LOT BOUNDARY

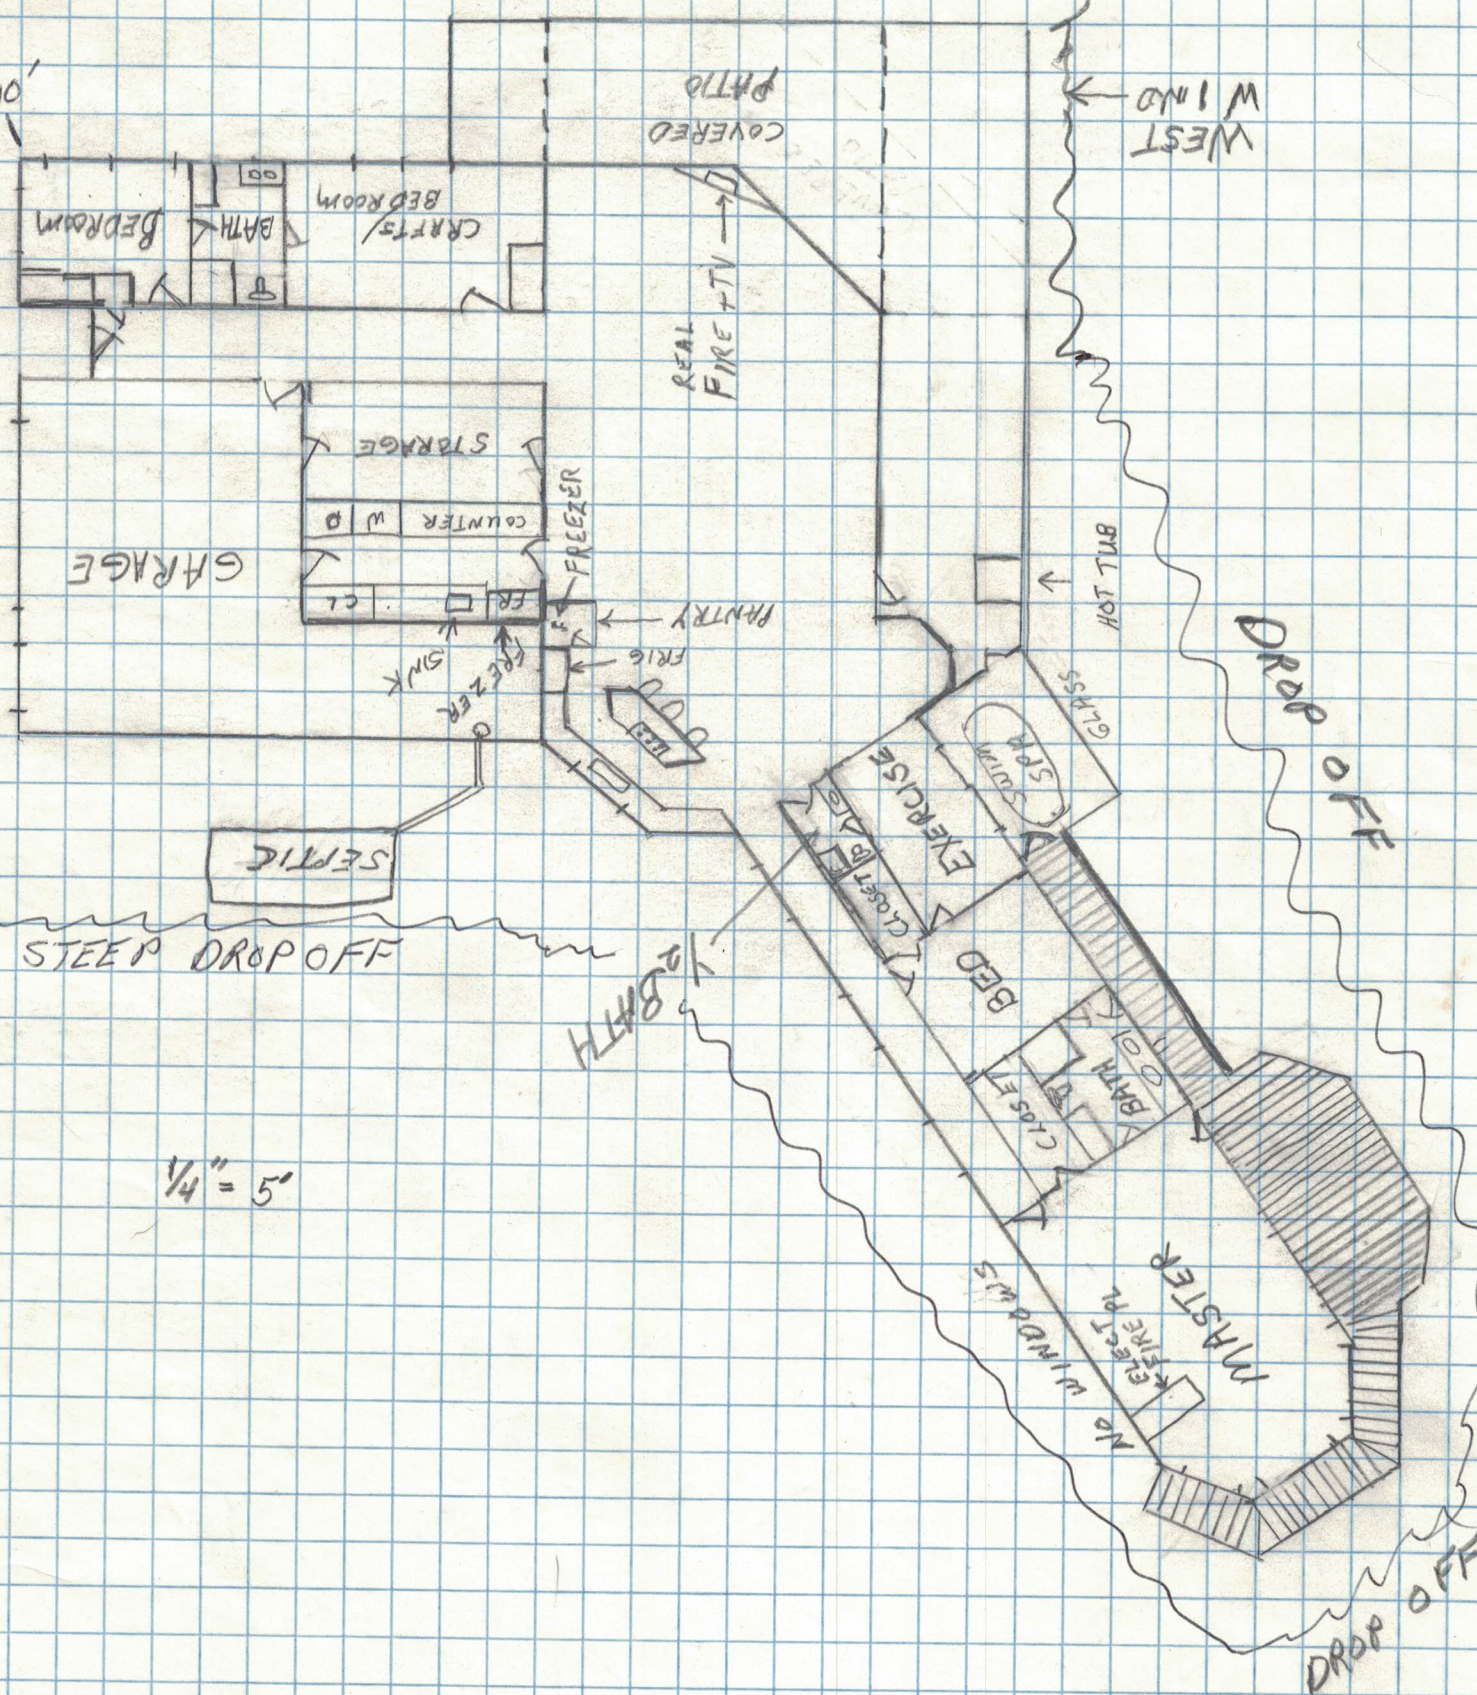
Please put all items on one site plan,
I have attached an example

Please add the following:
Owner name, contact telephone number and email
Applicant name, contact number and email
Property address
Property tax schedule number
Legal description
Lot size
Lot area coverage calculation
Current zoning of property

- Please show and label all easements and driveways.

The driveway outline is inconsistent with the last page in the submitted site plan. Please revise.

This plan is inconsistent with page 3.

- Please add the following:
- Date, north arrow and graphic scale
 - Show all property lines and dimensions
 - Add the square footage of the proposed home
 - Add setback distances from the proposed home and all property lines
 - Include any driveways
 - Location of all existing and proposed utility lines
